## PROPOSED COFFS HARBOUR CULTURAL AND CIVIC SPACE DEVELOPMENT KNOWN AS “ALL WELCOME”

Report Ref: 19-212472\_Cap\_Stat\_Report\_R02a

Date: 18 June 2019

Philip Chun has been appointed to report on compliance with respect to parts C, D, E, F, H and J of the Building Code of Australia 2019.

LEVEL 04 FLOOR PLAN

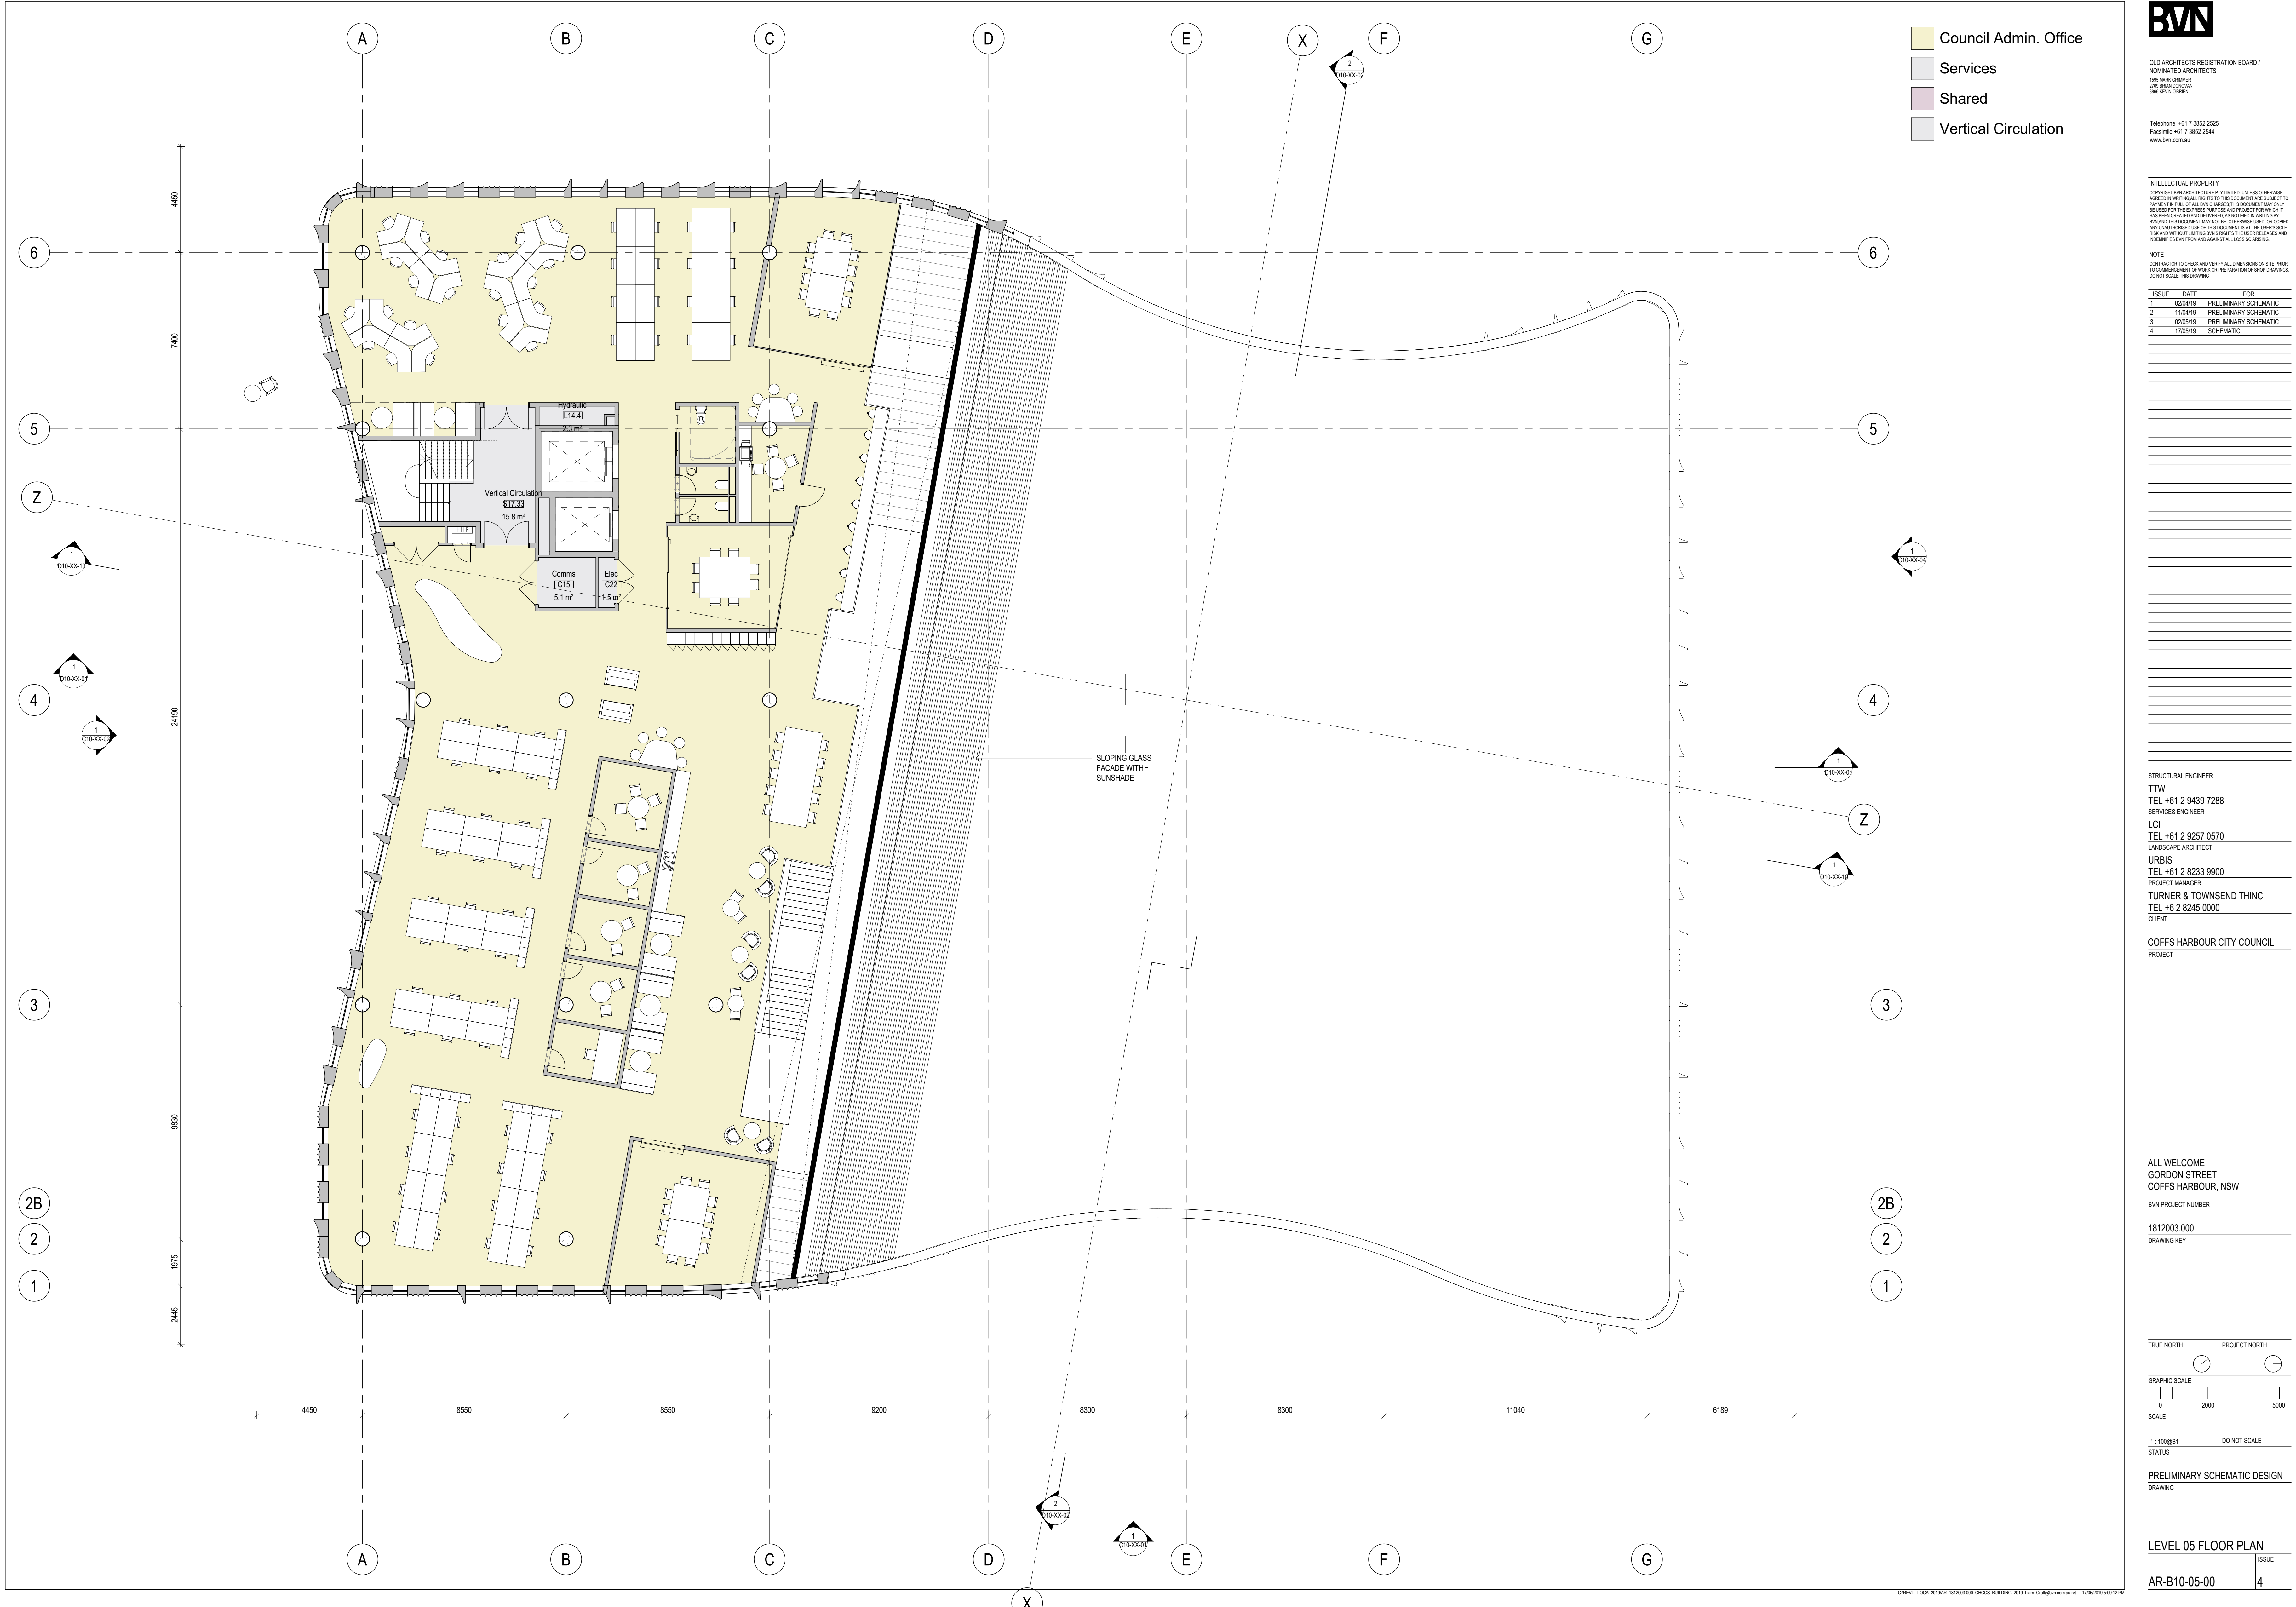
- (i) ***The class 7a basement part does not comply with travel distances up to 59m to a single exit in lieu of 40m max.***
- (ii) ***An additional exit door is required to the ground floor newspaper area.***
- (iii) ***Chiller plant room at L1 has 30m travel to point of choice of exits in lieu of 20m.***
- (iv) ***Levels 2 and 3 have 44m (SEW L2) and 47m (NE L3) travel to a single exit in lieu of 40m.***
- (v) ***Level 4 and 5 have 37m travel to a single exit in lieu of 20m max.***

***A fire Engineered solution is being carried out to address the above items.***
